Principal Issue in question	Concern held	What needs to change/be amended/be included in order to satisfactorily address the concern	Likelihood of concern being addressed during Examination
<p>E01: Overstatement of wider economic benefits of the proposal</p>	<p>TDC believes the level of increase capacity attainable from the NRP presented by GAL is overstated, leading to an overstatement of demand forecasts. TDC contests that the methodology used to derive these numbers is best practice or robust. As a result, the wider economics benefits of the proposal have been overstated and it is unclear that there is an economic case for the expansion of Gatwick.</p>	<p>Full modelling of the interaction between the use of the two runways and the respective departure routes needs to be undertaken and the delay information provided at a sufficiently granular level (hourly) to enable the delays to be properly understood and the capacity attainable validated.</p> <p>Robust market analysis and specific modelling of the share of demand that might be achieved at Gatwick in competition with other airports, not limited simply to traffic, including that from other regions of the UK, that has historically

Diagram 3.3.1: Model performance before and after adjustment, Generic zone

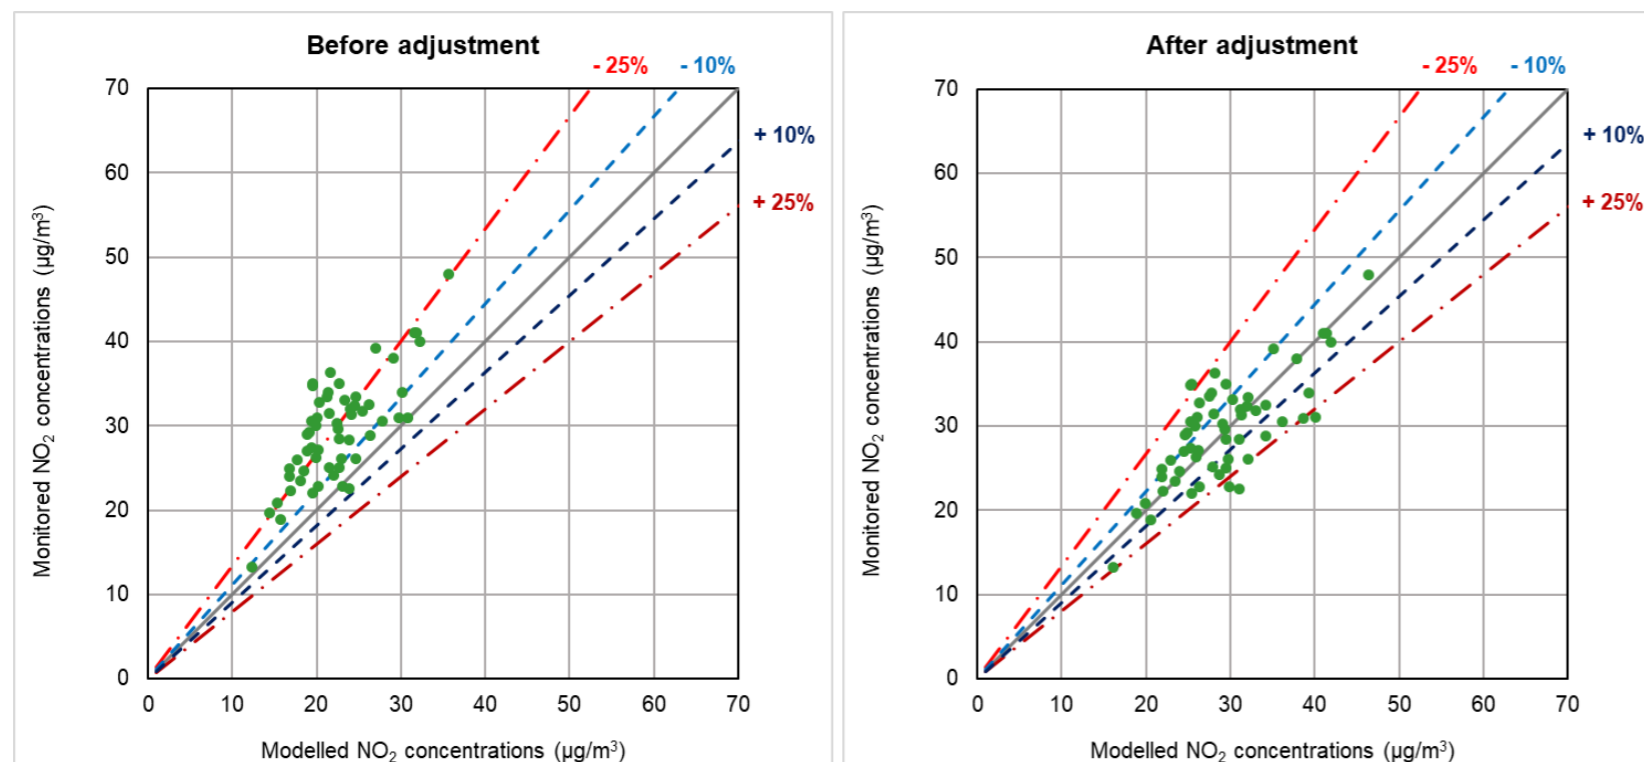
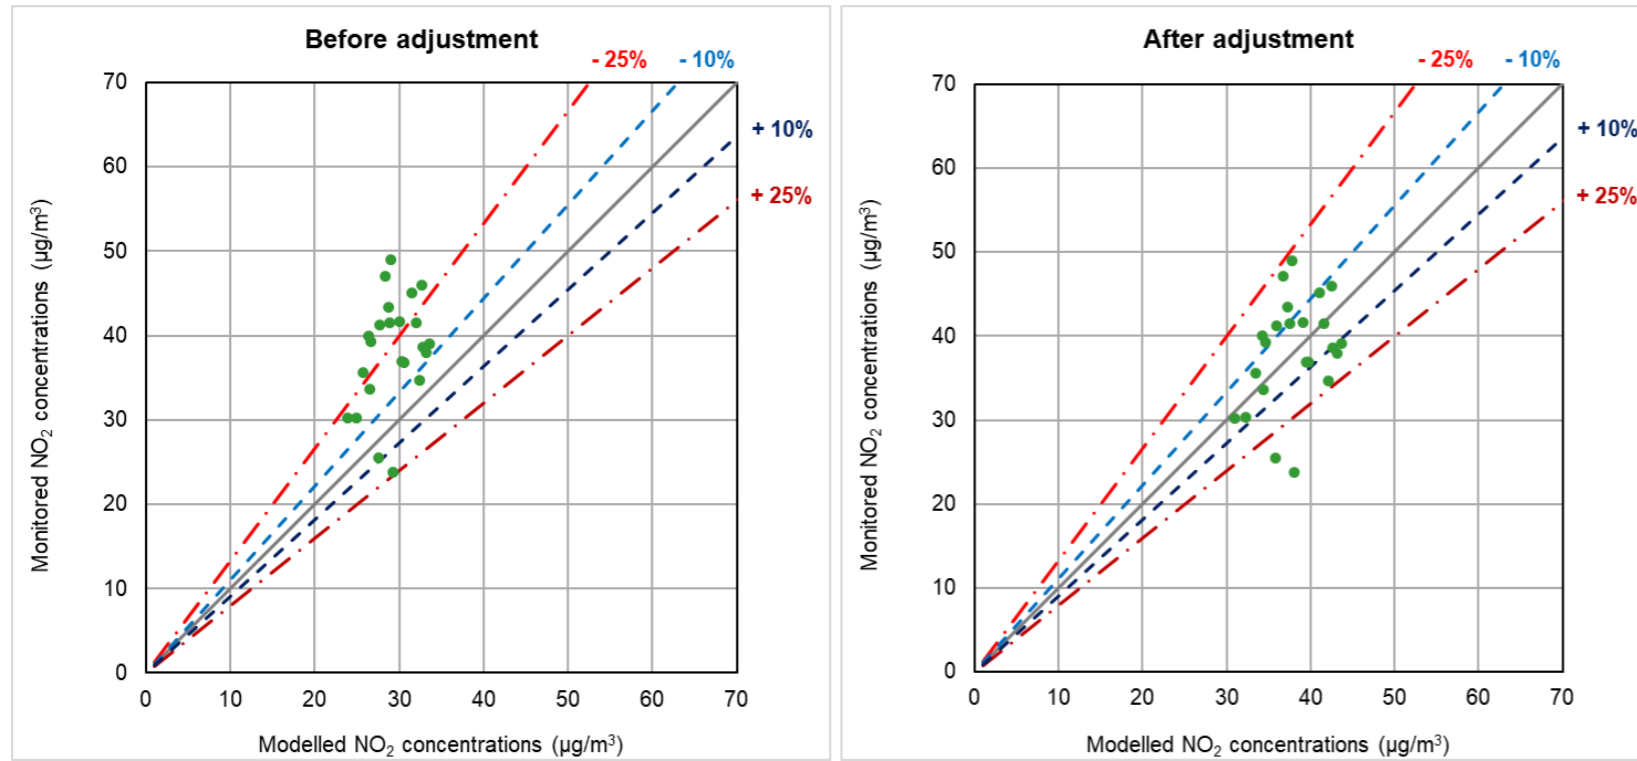
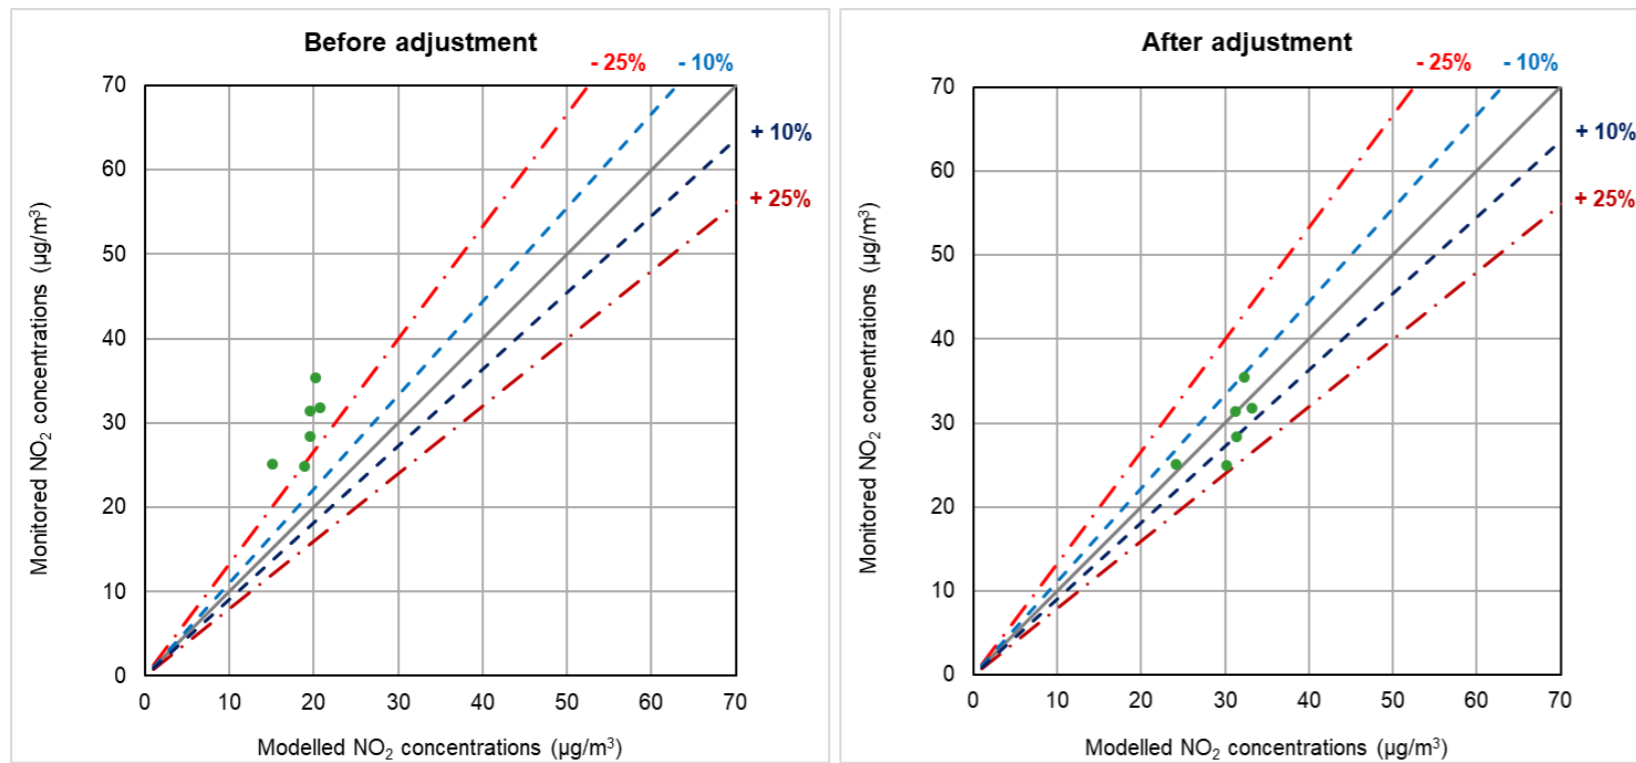
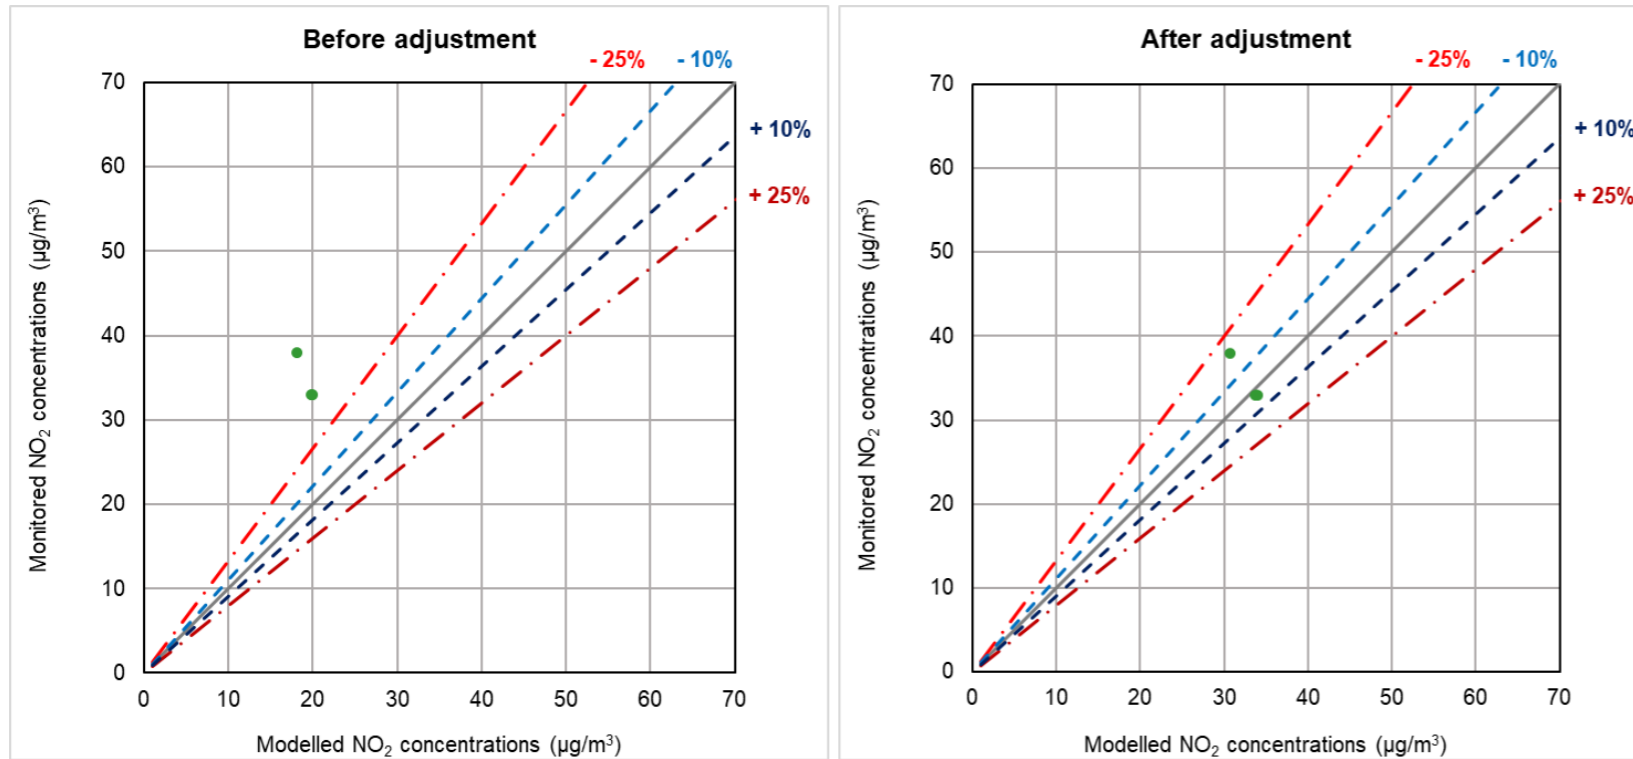
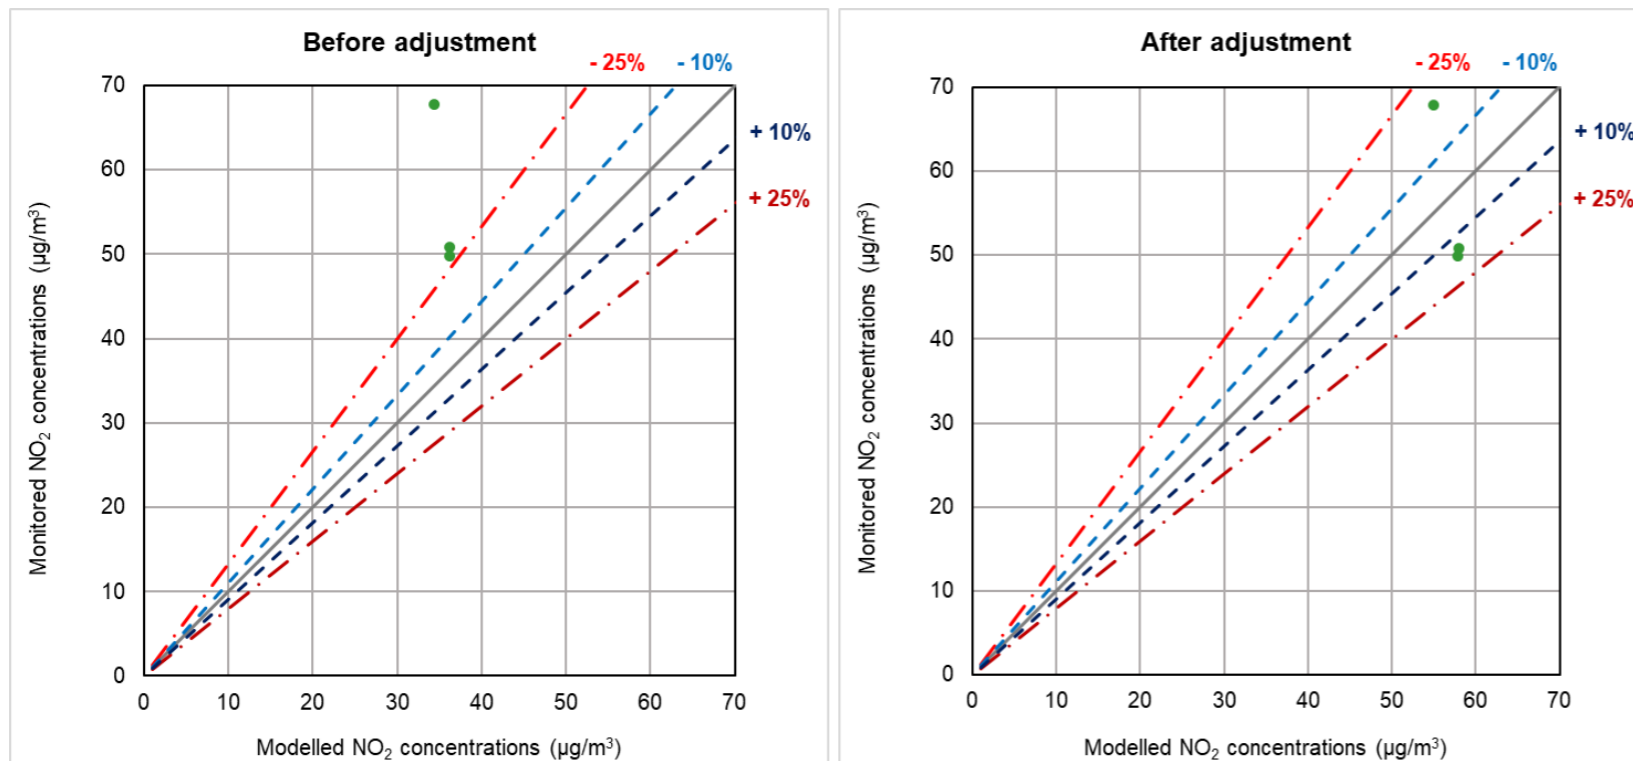
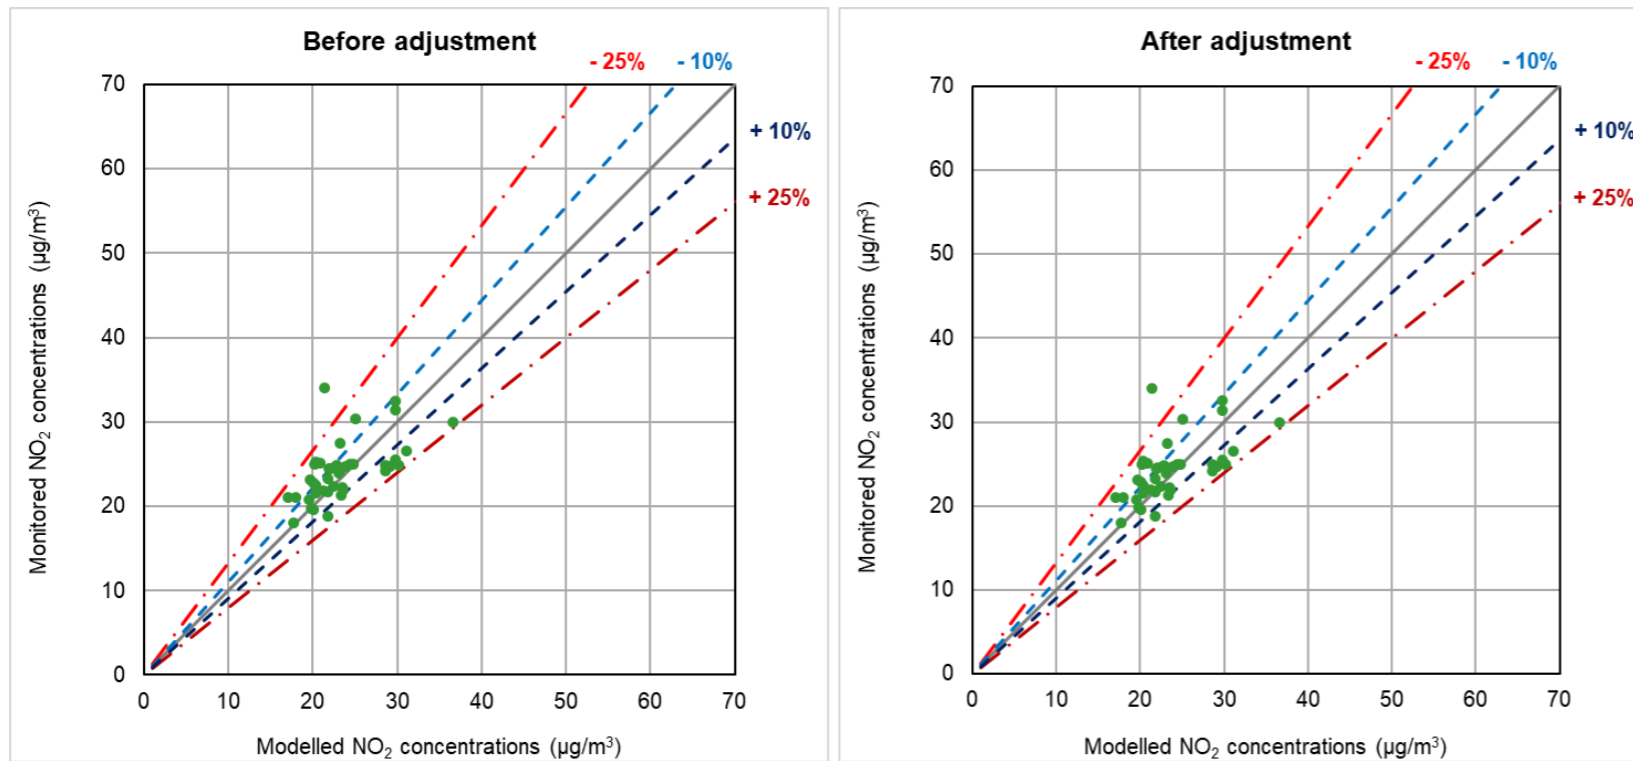
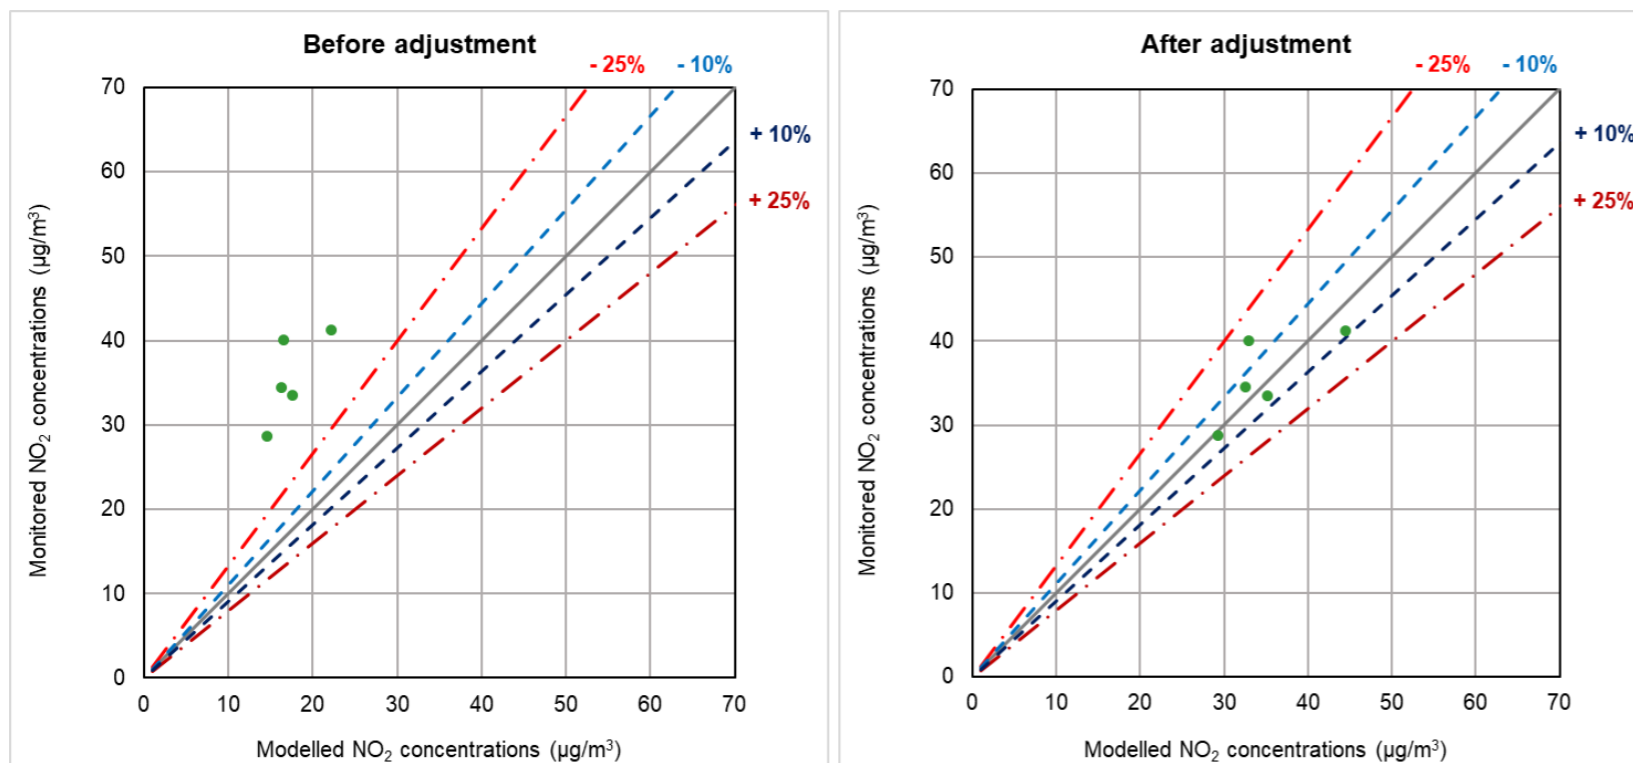
Principal Issue in question	Concern held	What needs to change/be amended/be included in order to satisfactorily address the concern	Likelihood of concern being addressed during Examination
AQ06: Monitoring sites	TDC is concerned that excessive numbers of monitoring sites may have been excluded from model verification which could have improved the quality of the air quality verification and so the confidence in outputs.	Further details on the sites excluded on this basis is required. Further details could be added to Table 3.2.2 of Environmental Statement Air Quality Appendix 13.6.1 to address the clarification points.	Uncertain
AQ07: Verification zones	TDC disagrees that enough justification was provided for the selection of different verification zones and why the model would be expected to perform differently in each area. A sensitivity test is required to demonstrate that the conclusions of the assessment would not change if a single verification factor were used.	A sensitivity test is required to demonstrate that the conclusions of the assessment would not change if a single verification factor were used.	Uncertain
